Please ask for: Nicola Moore  
Email: [nicola.moore@arun.gov.uk](mailto:nicola.moore@arun.gov.uk)  
Telephone: Ext 37944  
Our Ref: AL/83/21/PL  
Your Ref:  
Date: 25th June 2021

**Application for Planning Permission**

**Development:** Conversion of existing storage building & garage to 1 No. 3 bed dwelling. including new access to existing dwelling. This application is in CIL Zone 2 and is CIL liable as new dwelling.  
**Location:** Land Adj To 1 Hook Lane Westergate PO20 3QL

PROPOSED FIRST FLOOR PLAN
scale 1:100

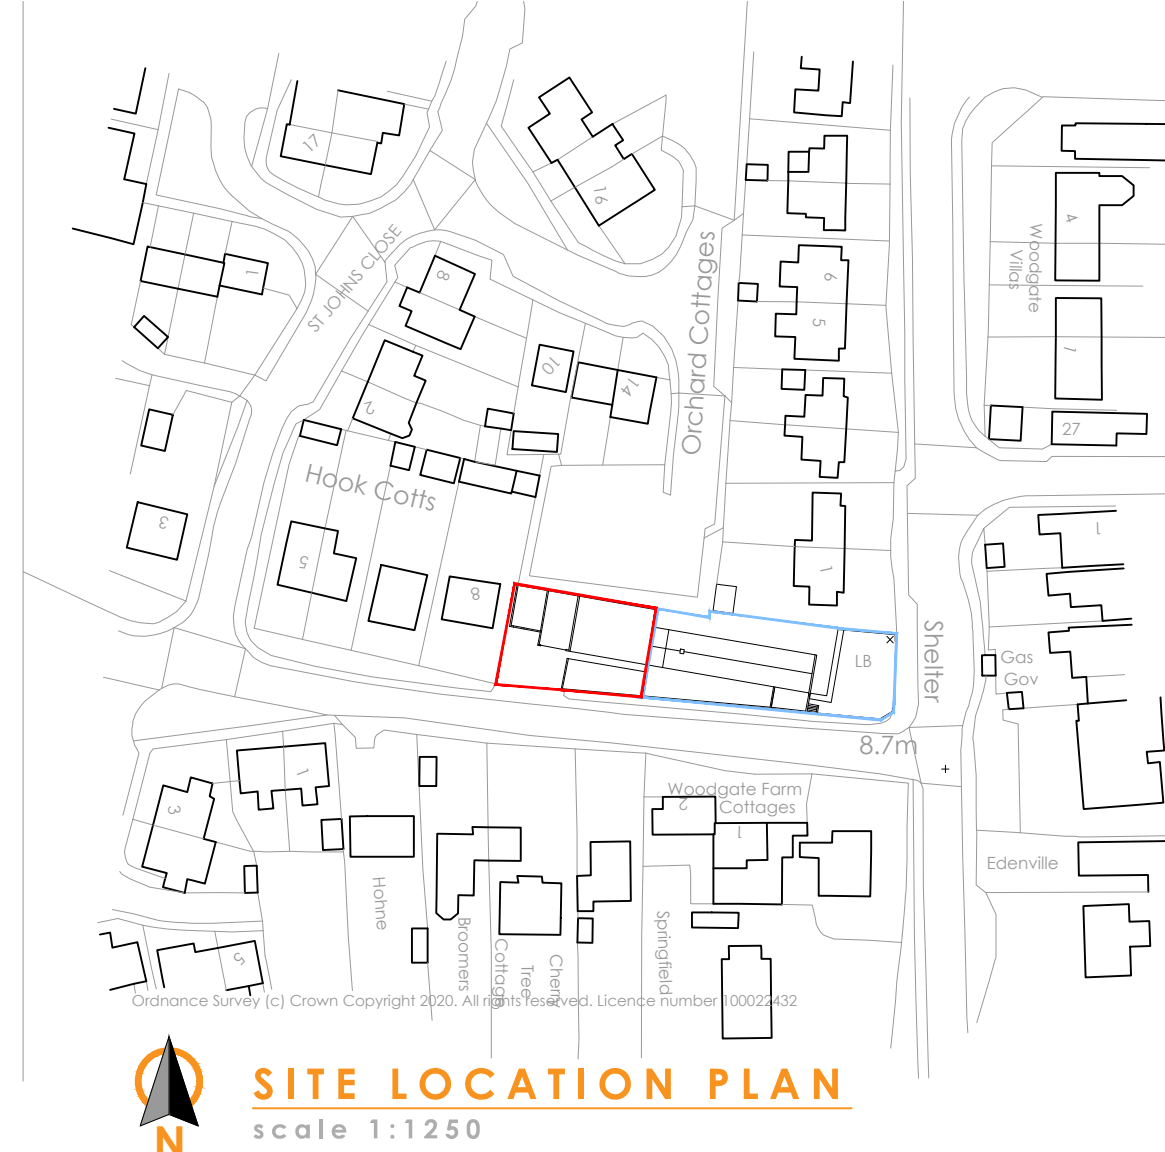
For clarity please confirm the number of bedrooms, as the application form shows 2 bed and the floor plan shows 3 bedrooms
